**CITY OF
PARRAMATTA**

SUBMISSION

In response to the exhibition of the State
Significant Development Application for the
Telopea Stage 1A and Concept Plan
22 November 2021

**Figure 4:** Plan indicating extent of public open space and encroachment of basement.

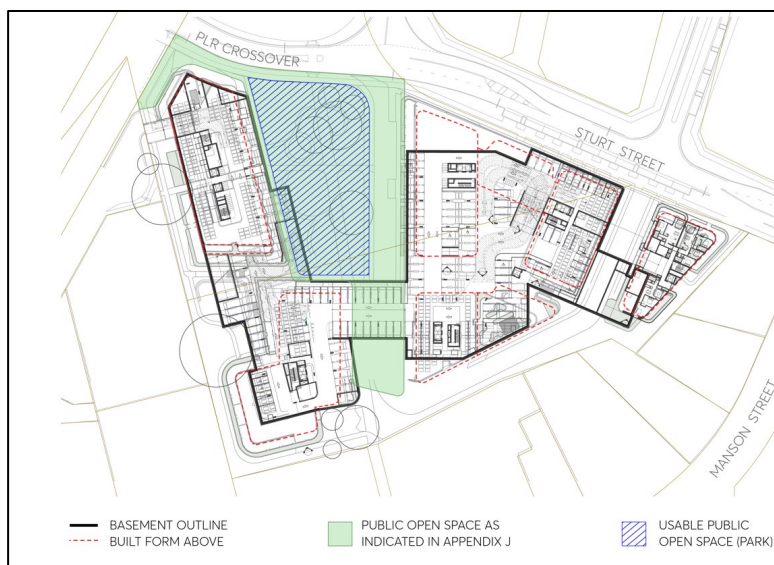
2. Removal of the underground carparking that encroaches along the south-western interface (refer Figure 3 below) and is to be removed to ensure deep soil throughout.
3. Design amendments as detailed in **Attachment B** Technical Assessment.
